Application for a non-material amendment following a grant of planning permission.

Erection of a multi-franchise car dealership (sui generis use) with offices (B1 use class), workshops (B2 use class) and car storage (B8 use class), together with car parking, cycle parking, boundary treatment, landscaping, lighting and access.

Reference number:	<input type="text" value="6/2019/1411/MAJ"/>
Date of decision	<input type="text" value="04/09/2020"/>

project	Hatfield Plot 5000A H R Owen	drawn by	KM
status	Updated for NMA application	checked by	RG
title	Planting Plan 1 of 2	date	14.02.19
Xref	xref	scale	1:250@a1
drawing No	1226-201	revision	E

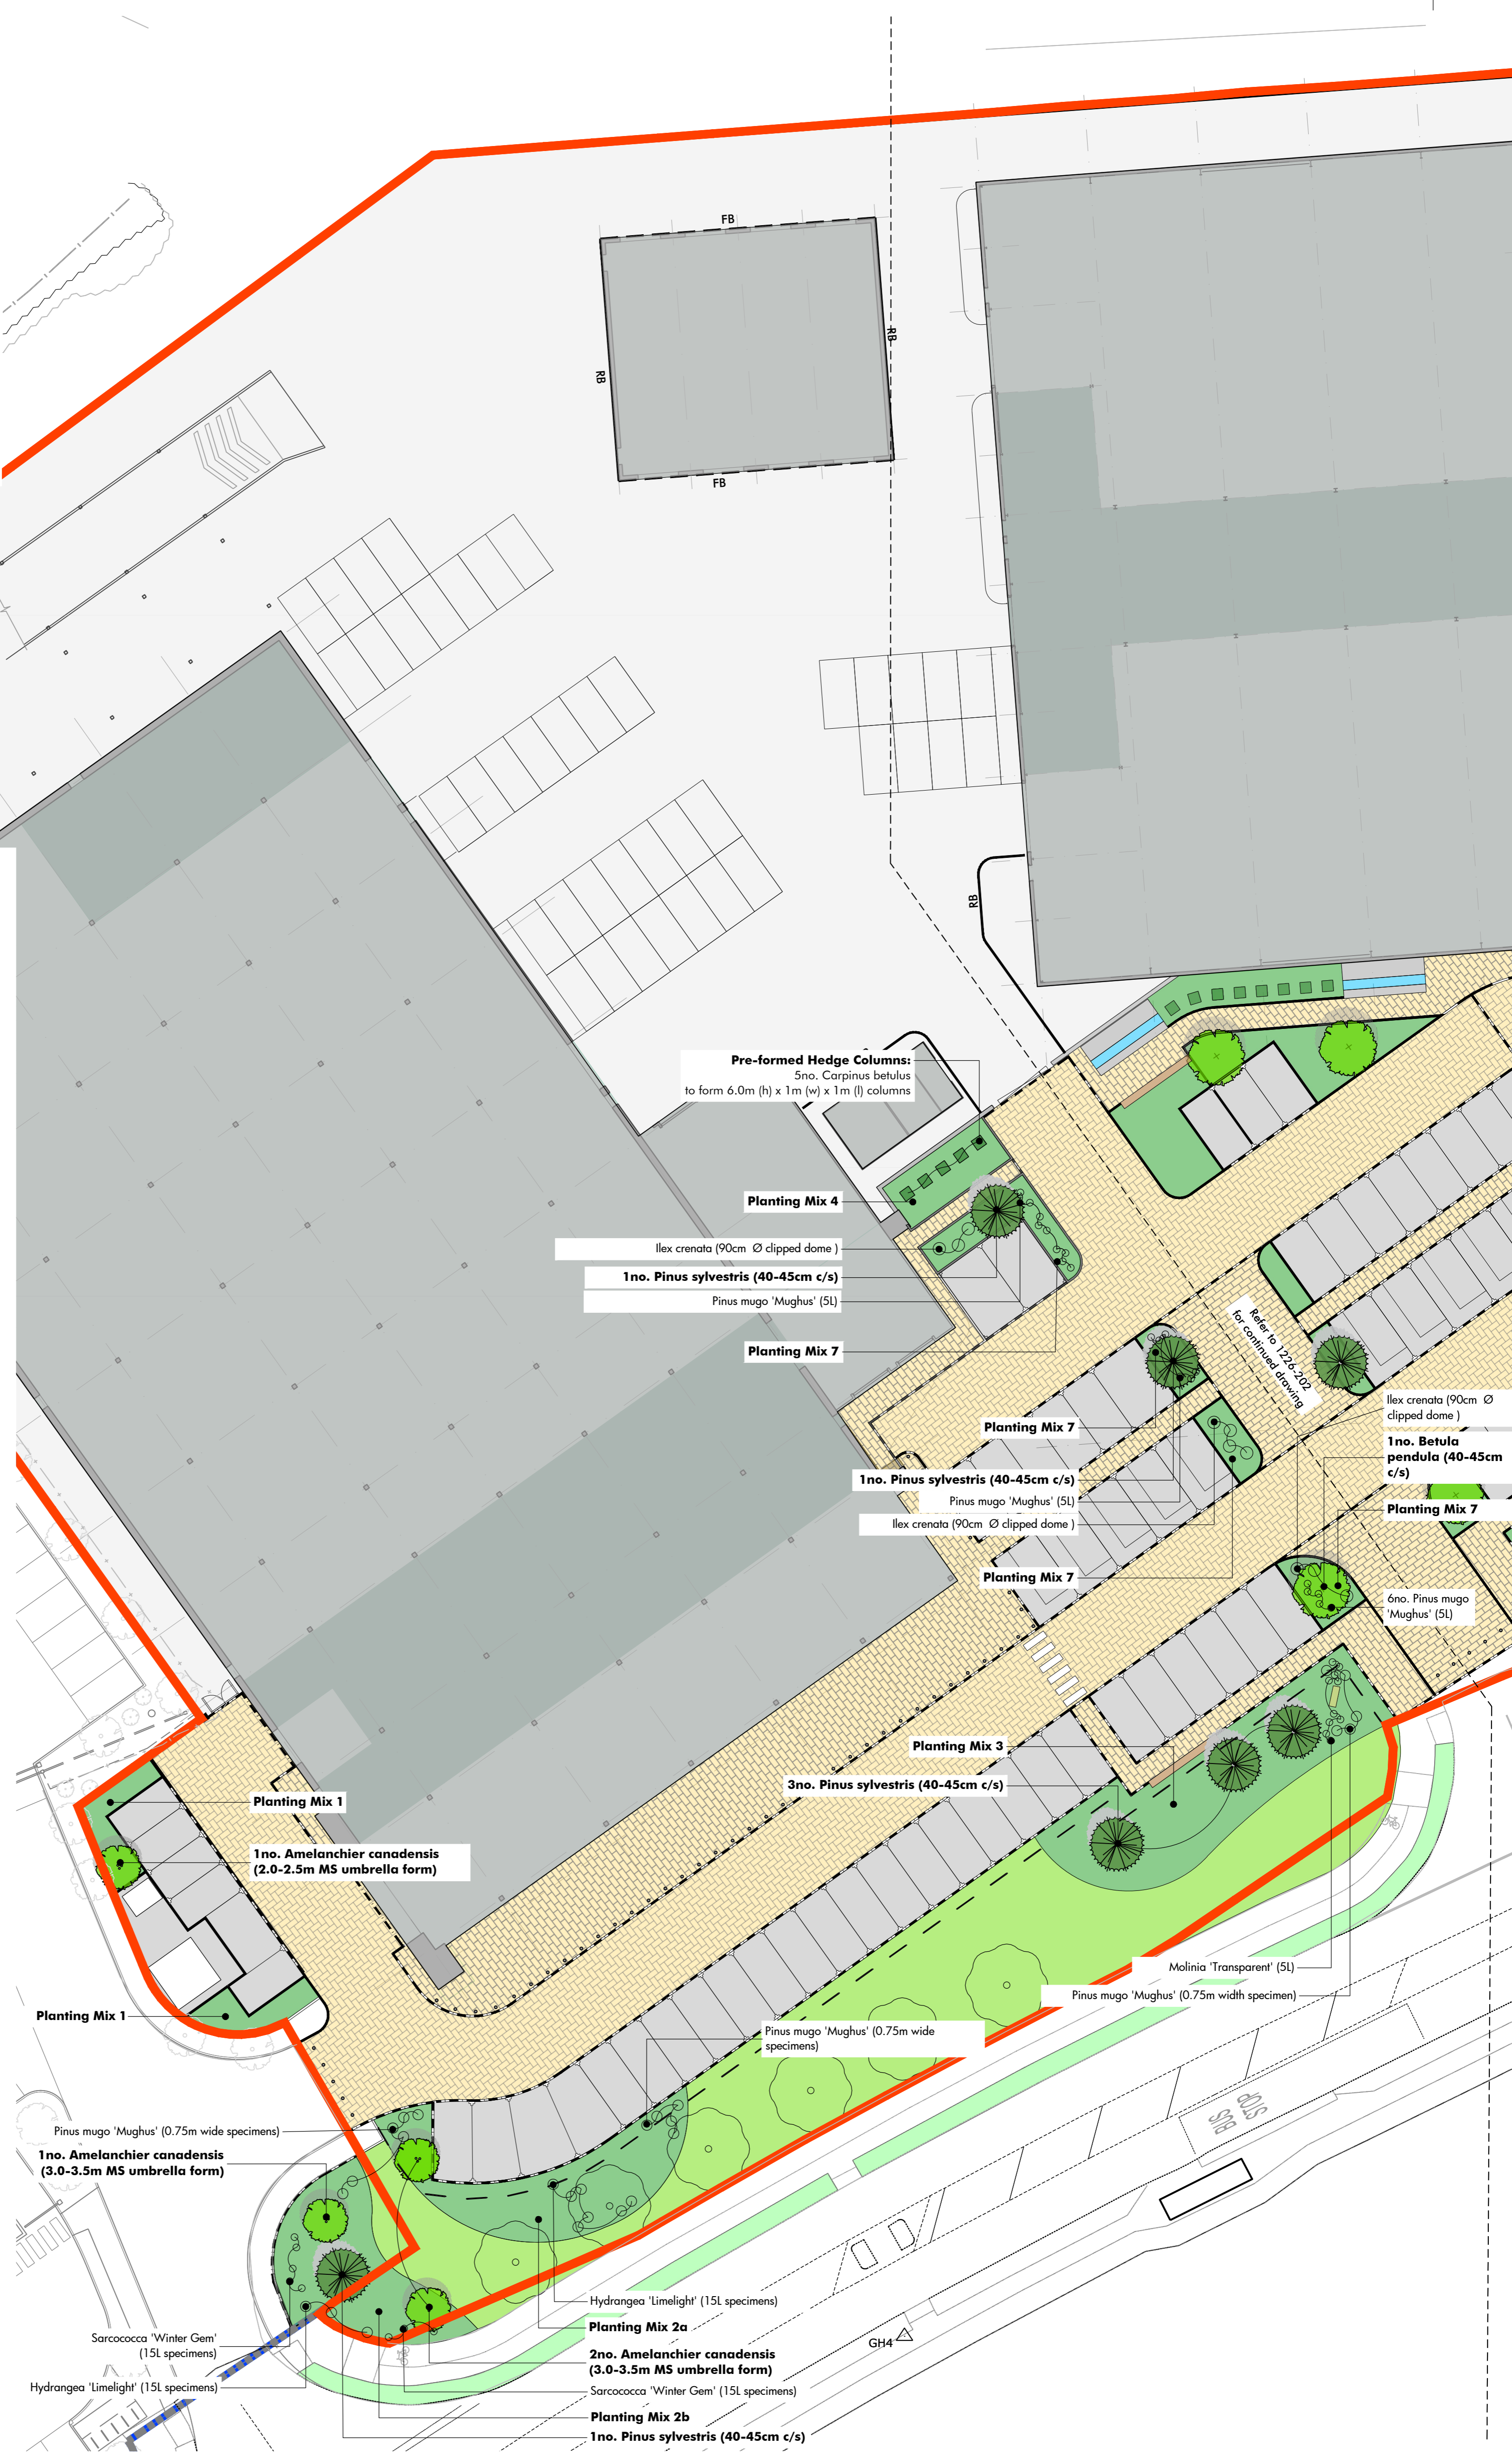
- Reduction of 22 car parking spaces across the development. (This still falls within the range approved under the original outline planning permission for the Business Park).
- Minor adjustment to the landscaping in the south-west corner of the site to accommodate the sub-station and service ducts.

| Drawing Title | | | |
|----------------------------------|------------|----------|------------|
| East Showroom Complex Elevations | | | |

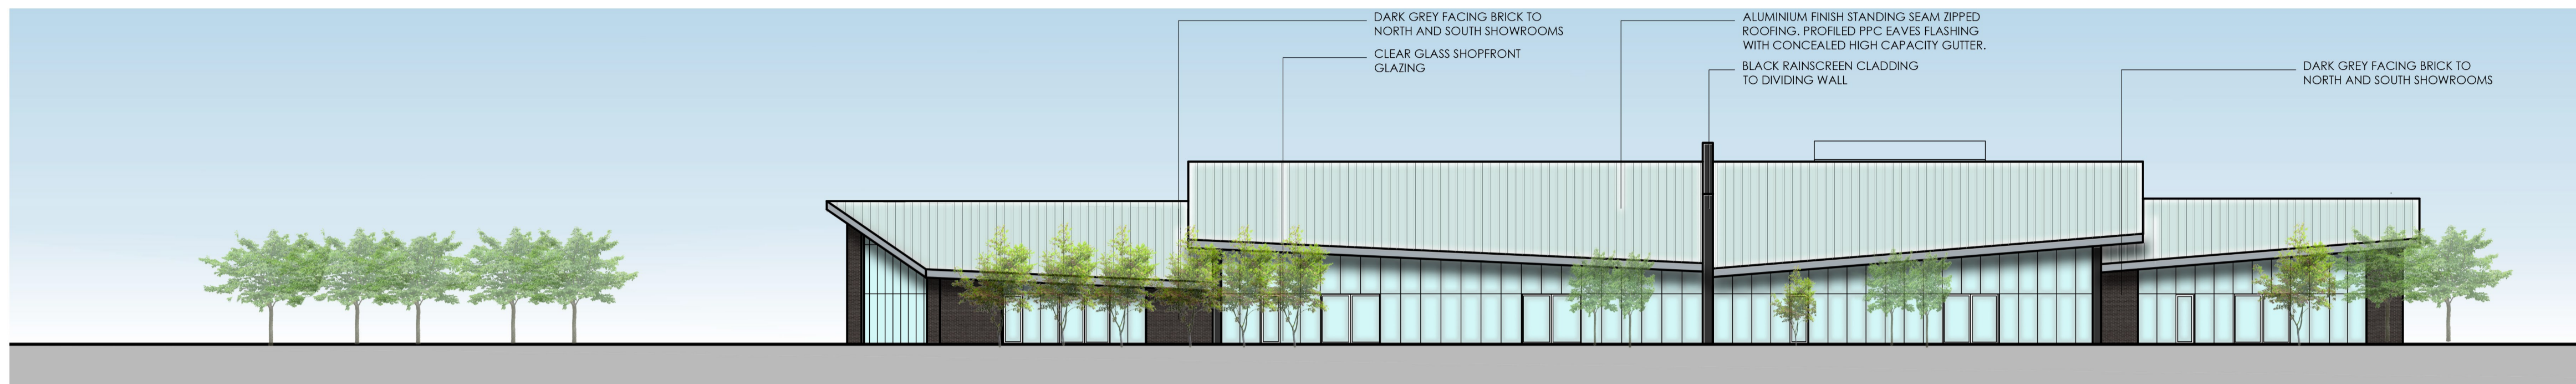
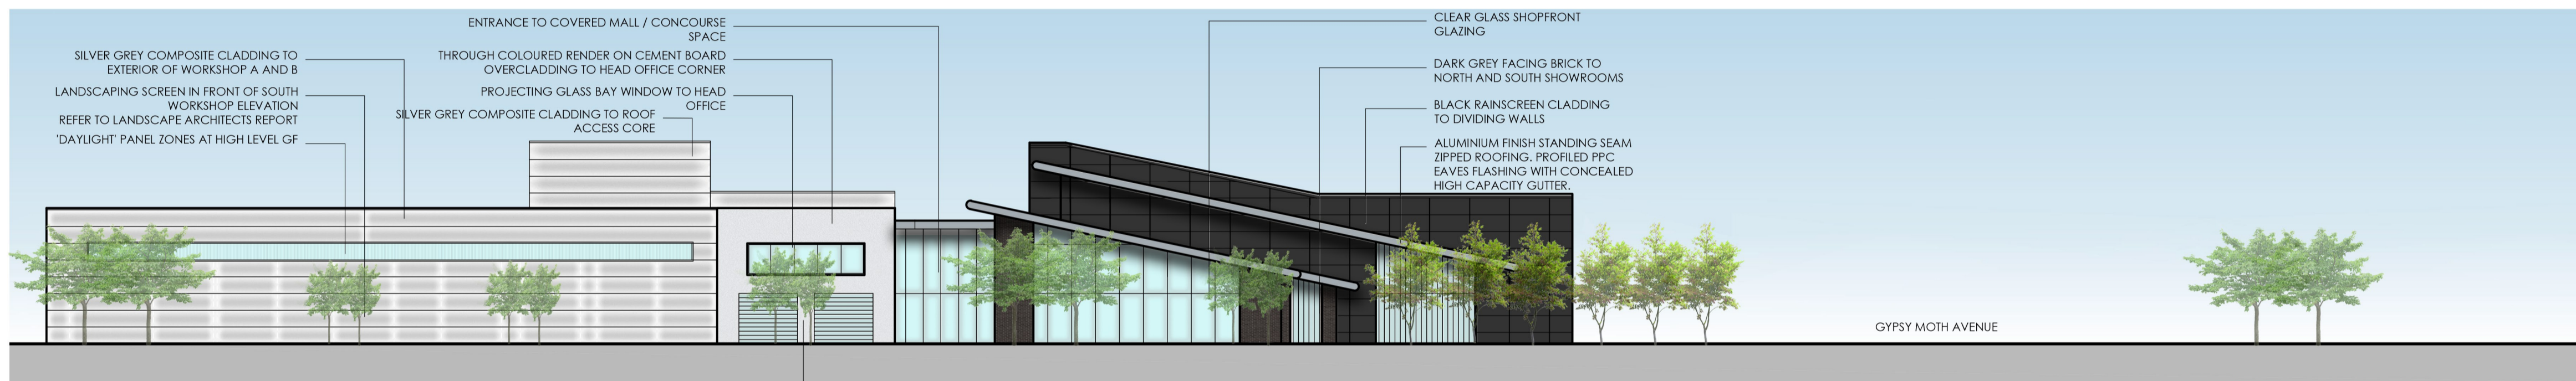
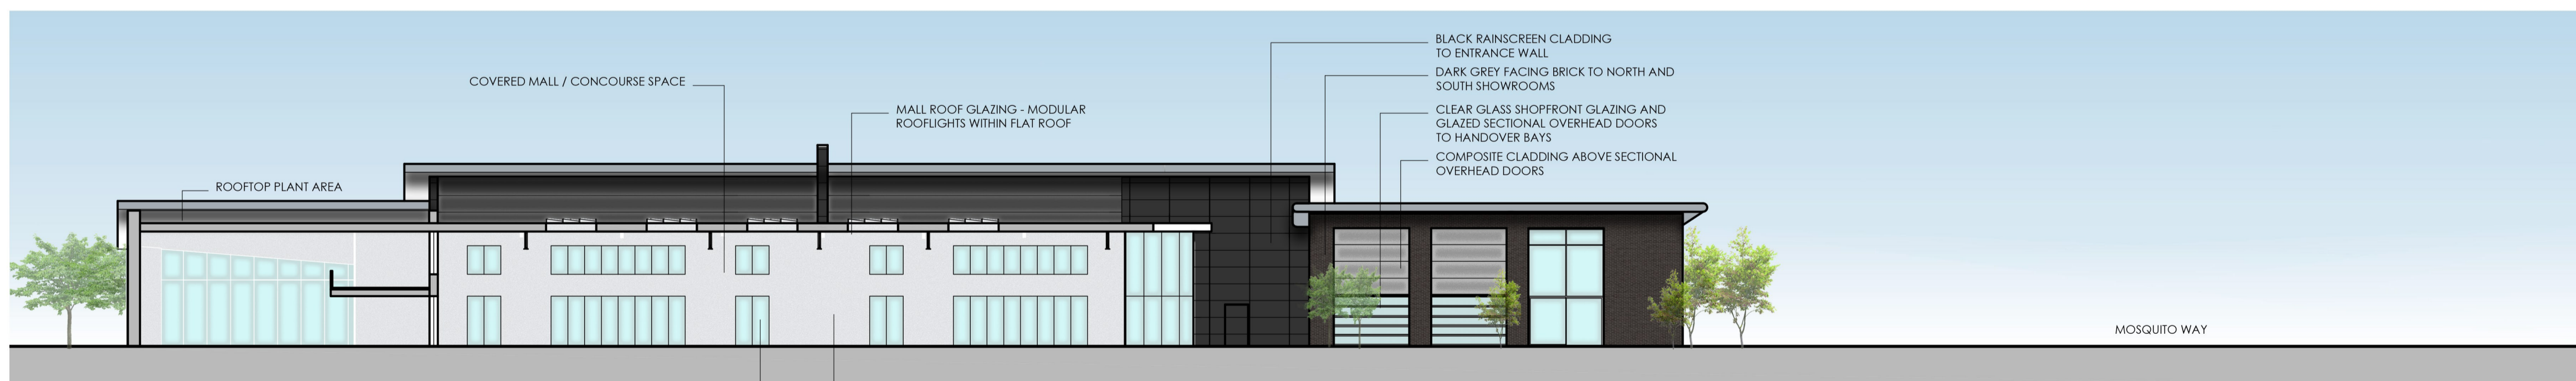
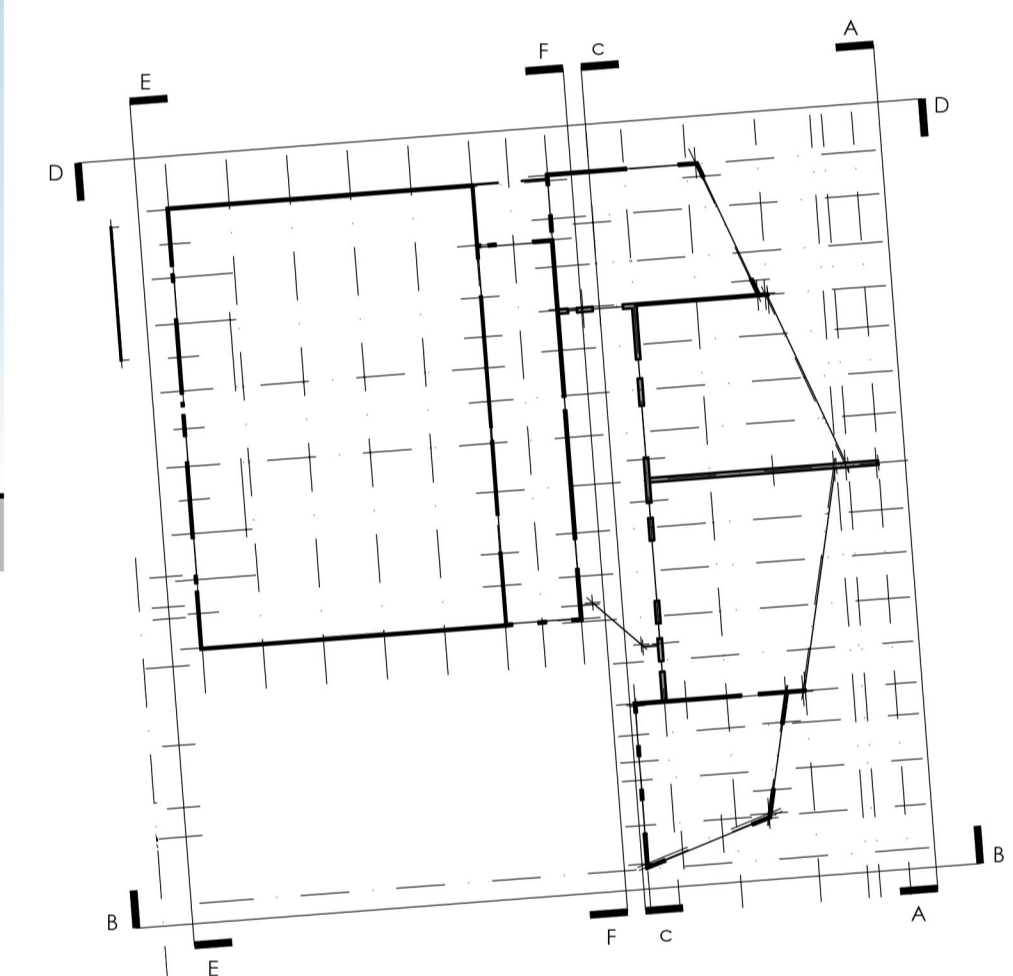
- Shape of mezzanine floor to Showroom amended
- Additional handover bay provided within Showroom B
- Shopfront glazing and openings amended to Showroom B
- Daylight panels to Workshop B amended
- Lift over-run and roof plant area parapets increased in height
- Spine wall between showrooms and customer mall / concourse altered to comprise both rainscreen and composite cladding
- Canopy to side of Workshop A omitted
- Position and design of central stair core altered
- Plant room and external plant areas amended
- High level window to staff canteen relocated
